MEMORANDUM

To: FILE
From: Jean Fraser
Subject: Application ID: 2015-085
Date: 6/17/2015

Comments Submitted by: Keith Gautreau/Fire on 6/17/2015

SITE PLAN
OF:
LOT 5 INDUSTRIAL WAY
81 INDUSTRIAL WAY
PORTLAND, ME 04103

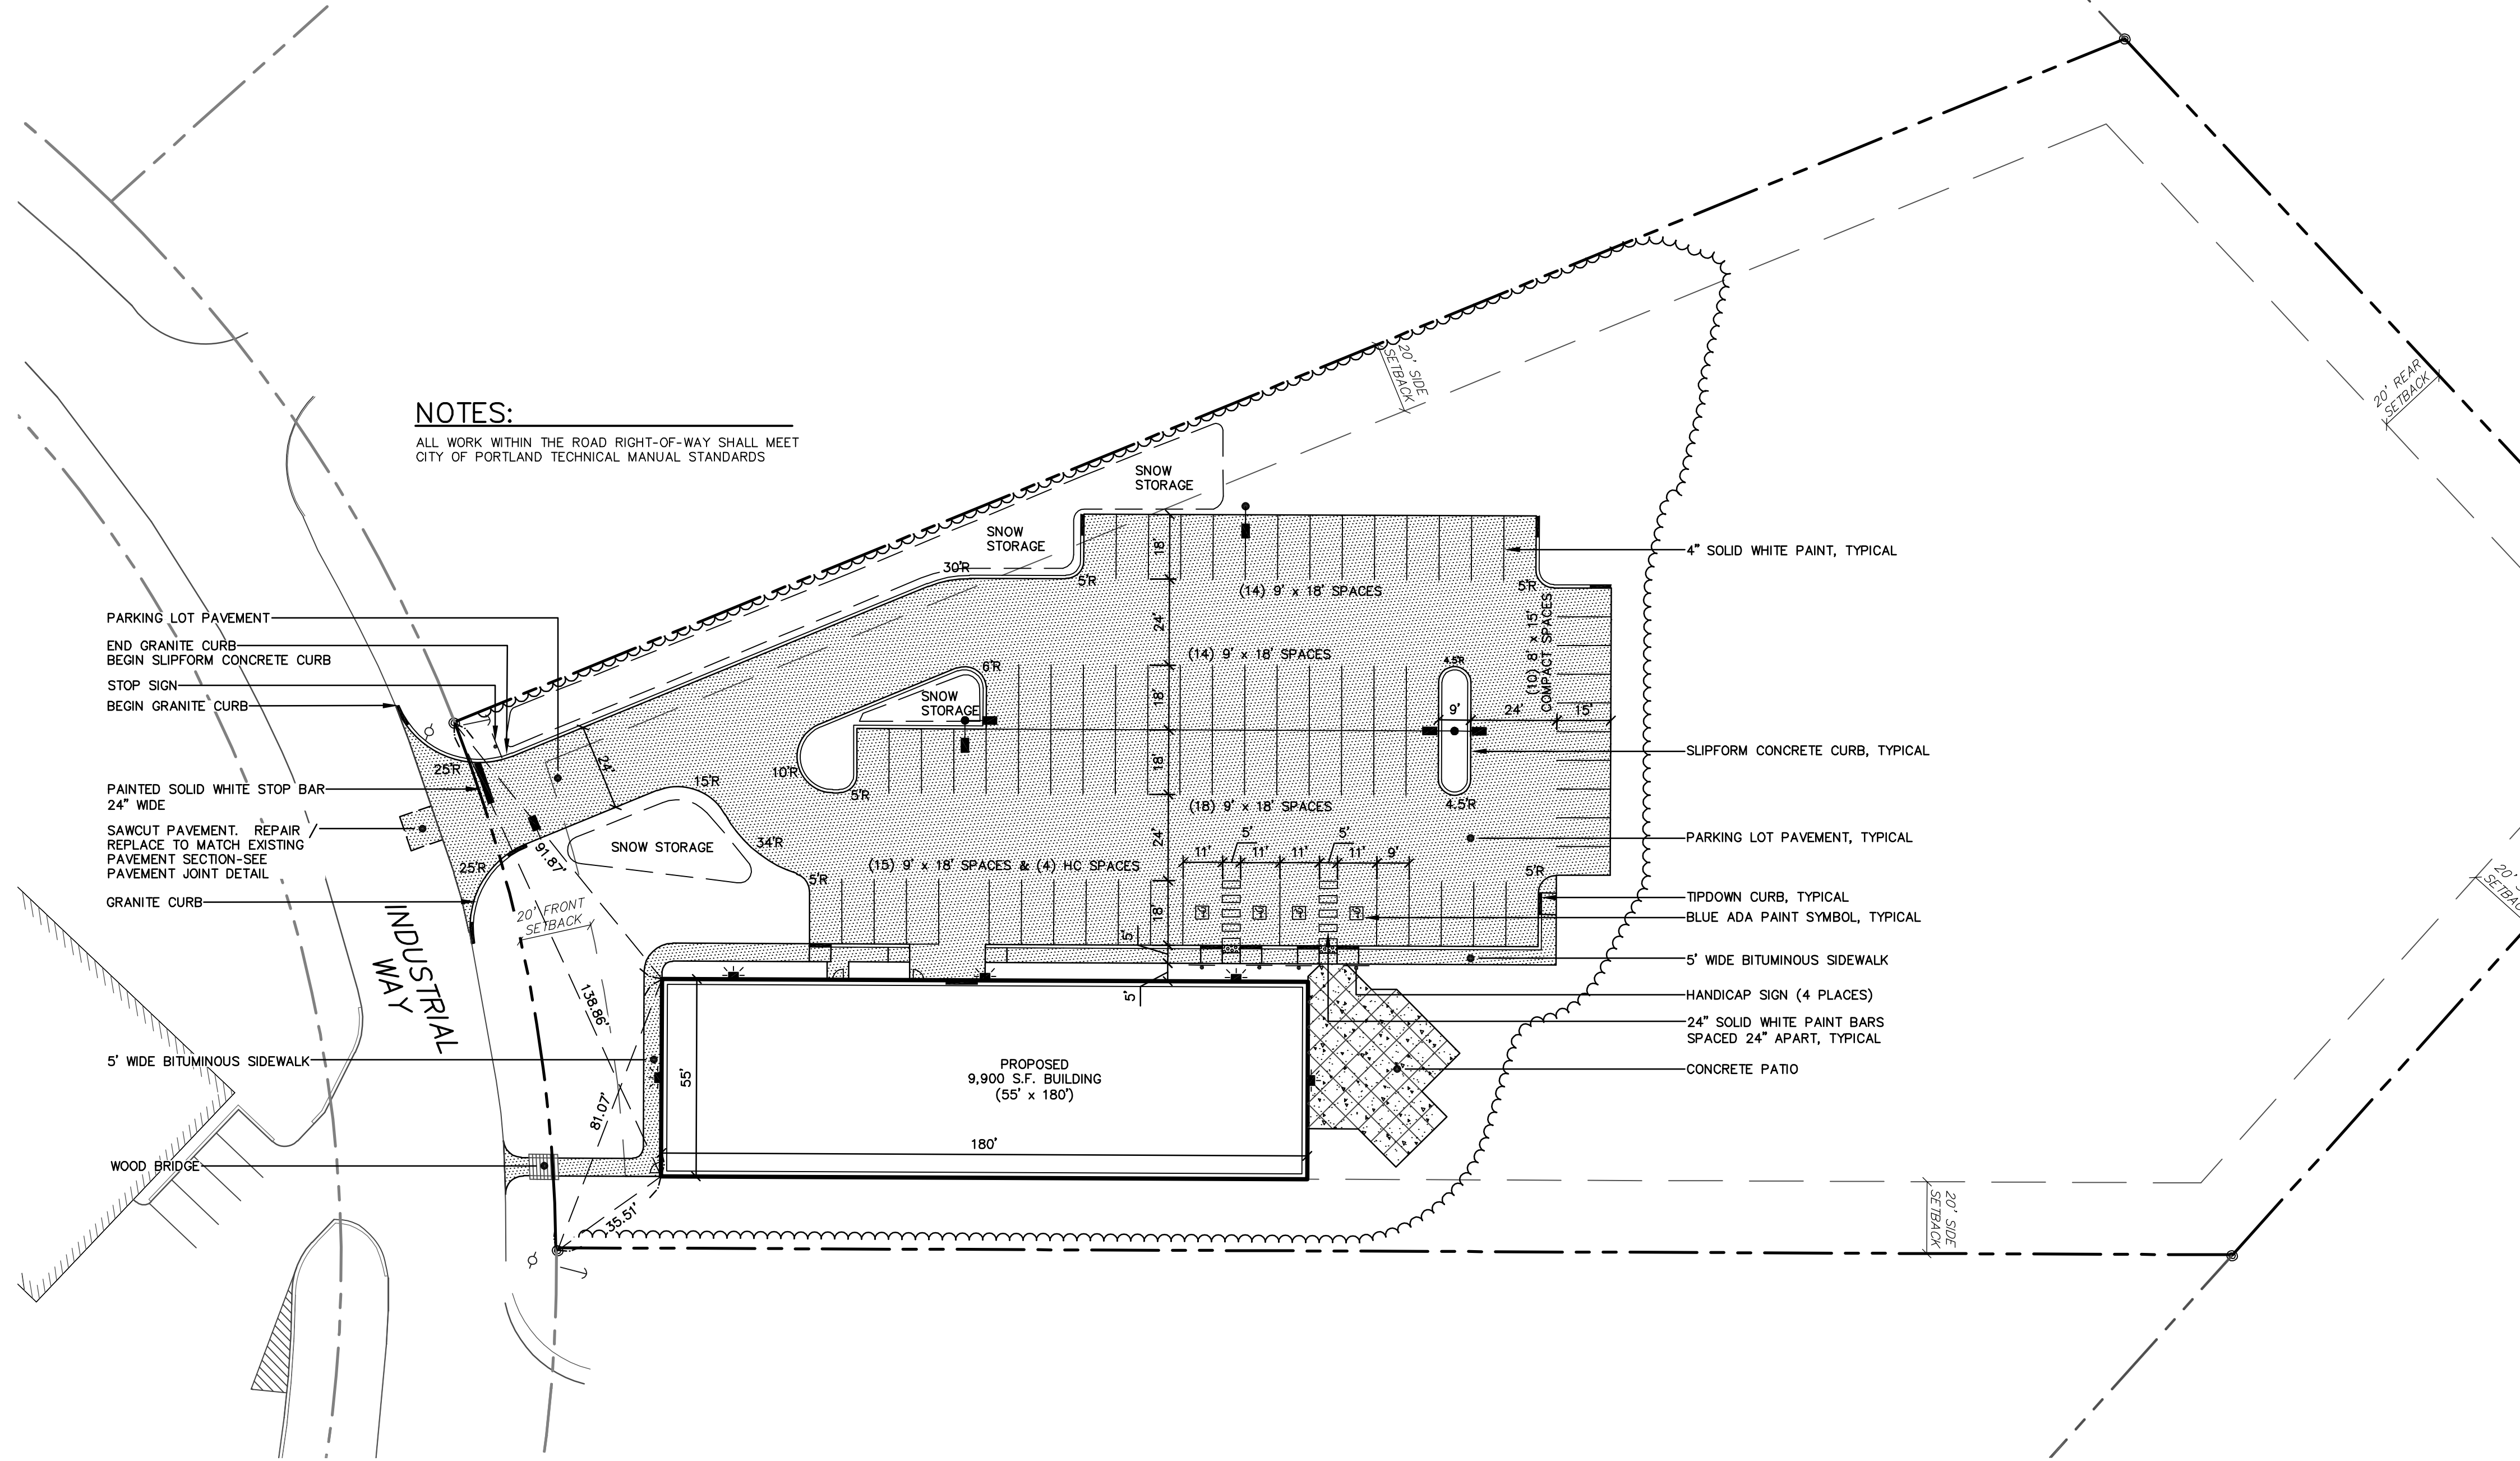
Access to the building overall looks good. We have access right side of building from the adjacent parking lot.

A Life Safety Evacuation Plan shall be submitted with the Building Permit detailing the exiting and waiting area for occupants.
